SSD 6010 - One Residential Building (Student Accommodation) within Darling Drive Plot

Submission by:

Patricia Cadell

21 July 2013

SHADOW DIAGRAMS: PERSPECTIVE, SHOWING THE PEAK, WINTER SOLSTICE

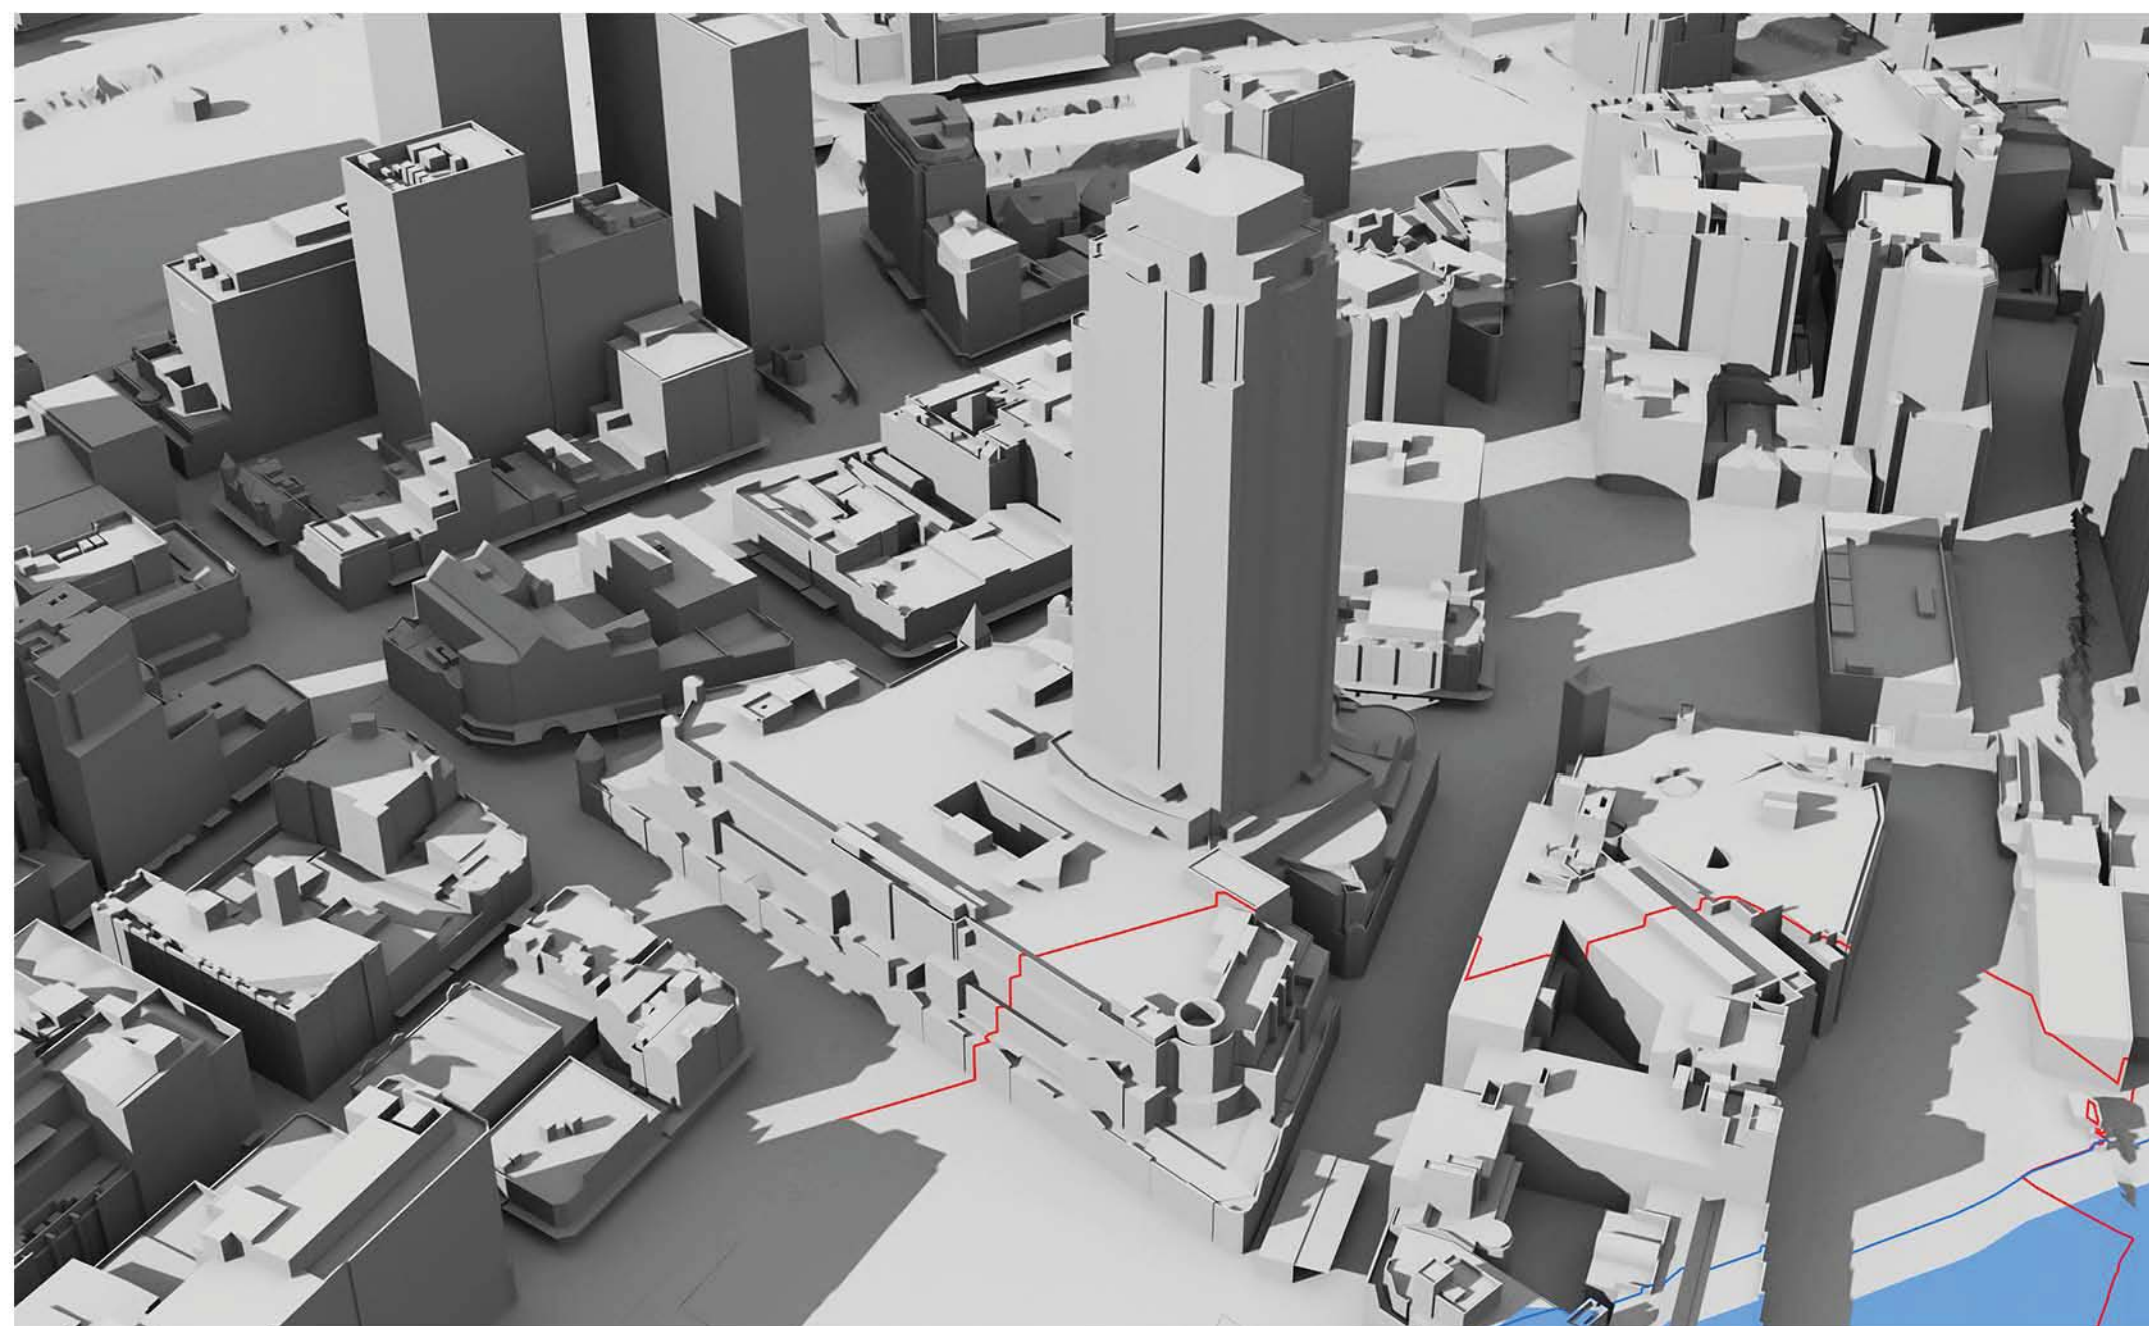
At 9am, 10am and 11am the west façade is totally in shadow due to other parts of The Peak building itself.

At 12pm there is still substantial existing shadowing on the west façade caused by the irregular shape of the west facade.

At 9am, 10am and 11am the west façade is totally in shadow due to other parts of The Peak building itself.

At 12pm there is still substantial existing shadowing on the west façade caused by the irregular shape of the west facade.
